From: Amanda Scholes on behalf of Planning.Responses
Sent: 26 July 2017 10:23
To: Planning Scanning
Subject: FW: PLANNING APPLICATION Y/40/17/OUT
Attachments: Great Crested Newt response.docx

Comments on the Great Crested Newt Presence/Absence Survey and Population Assessment: submitted by J. Rogers on behalf of F.R.A.

Figure 21. Locations of ponds in relation to the site with the sites approximate boundaries shown in red.

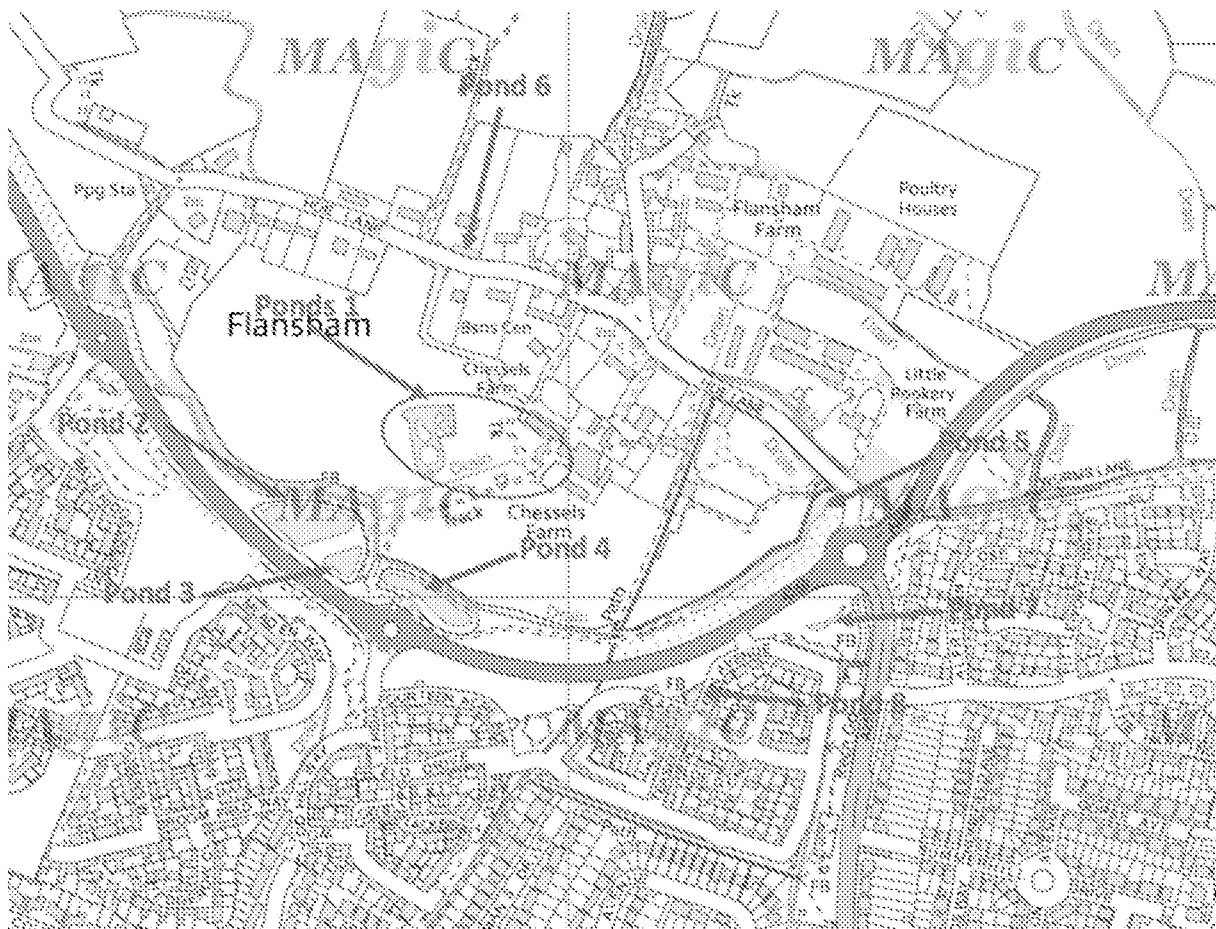
It should be noted that 3 ponds within the required 500m of the land at Bonhams were not surveyed for great crested newts despite the presence of great crested newts being recorded in Sussex Biodiversity Records Centre records in ponds within 280 metres of the Bonhams site in both 2016 and in this survey in 2017.

The report for this application shows that ponds 2 & 3 were visited just twice (April 5th 2017 and on April 17th 2017). Subsequent eDNA testing was carried out on these ponds, confirming the presence of GCN in pond 2.

Pond 4 was not surveyed 'as it had completely dried out at the time of the first visit'; as a great crested newt presence has been confirmed in at least one close-by pond over 2 consecutive years there is a risk that the territorial value of pond 4 to the great crested newt may have been overlooked due to lack of surveillance

Ponds 5 & 6 were visited only once (on April 5th 2017) Subsequent eDNA testing was carried out only on pond 6. Pond 5 was not DNA tested.

- The fact that only 1 or no visits were made to some ponds within 500m falls below Natural England's guidance for presence/absence surveys for the great crested newt, which also clearly states that great crested newts may be present in temporary ponds.

- In order to meet the Natural England's guidance these ponds should be surveyed.
